Our Ref: LM/ARU/20/07D

### **RE: Land at Ford Airfield Ford**

Thank you for your correspondence of the 1<sup>st</sup> of October 2024, advising me of a planning application for the approval of reserved matters (layout, scale, appearance, and landscaping) following outline permission F/4/20/OUT for phase reserved matters 1 (North), for the erection of 340 No. residential dwellings plus associated roads, infrastructure, parking, landscaping, open space & play areas, and associated works at the above location, for which you seek advice from a crime prevention viewpoint.

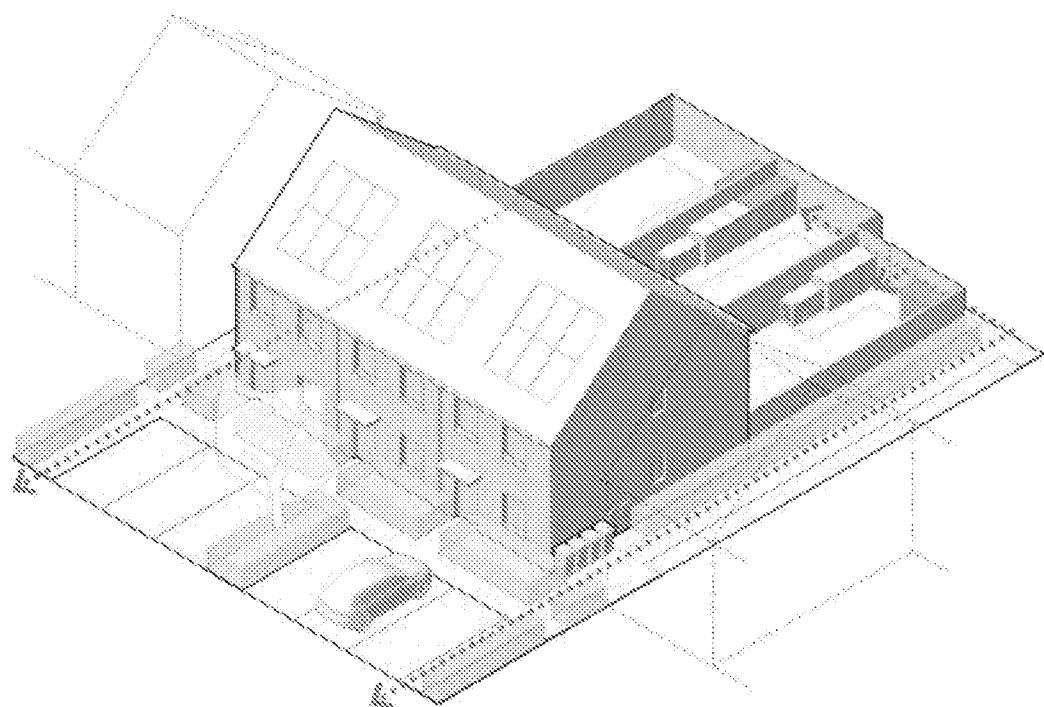
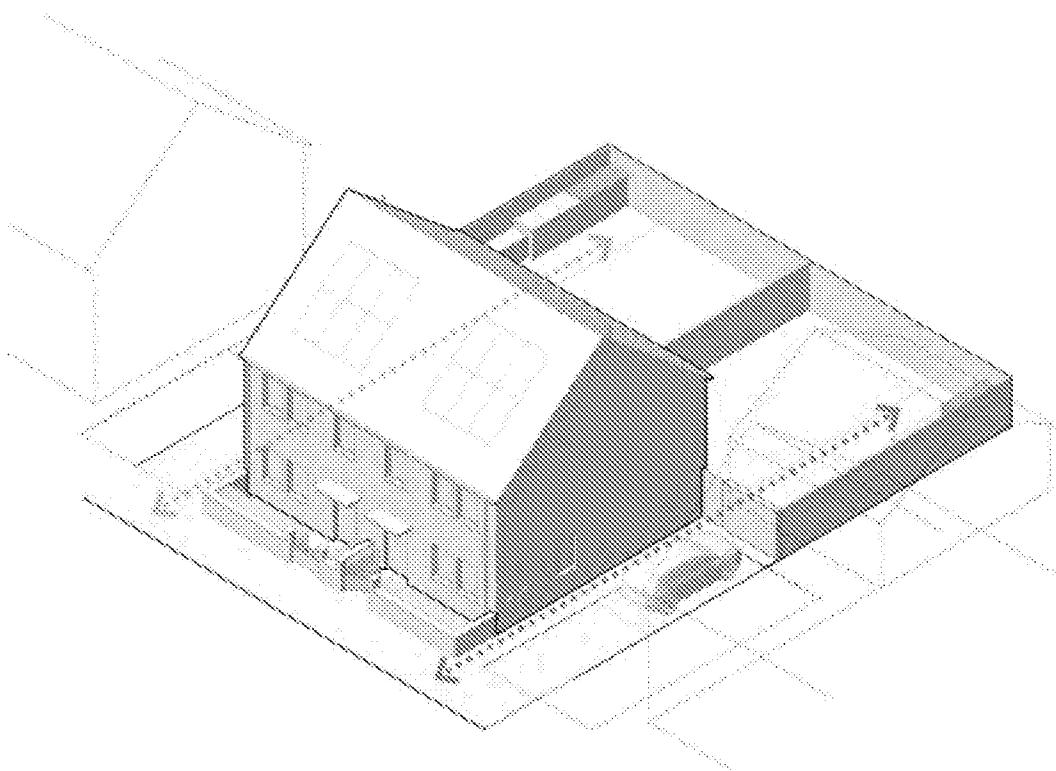
With regards to cycle storage throughout the development - research by the 'Design against Crime Centre' suggests that cyclists should be encouraged to lock both wheels and the crossbar to a stand rather than just the crossbar and therefore a design of cycle stand that enables this method of locking to be used is recommended. The minimum requirements for such equipment are as follows:

- Galvanised steel bar construction (minimum thickness 3mm), filled with concrete;
- Minimum foundation depth of 300mm with welded 'anchor bar'.
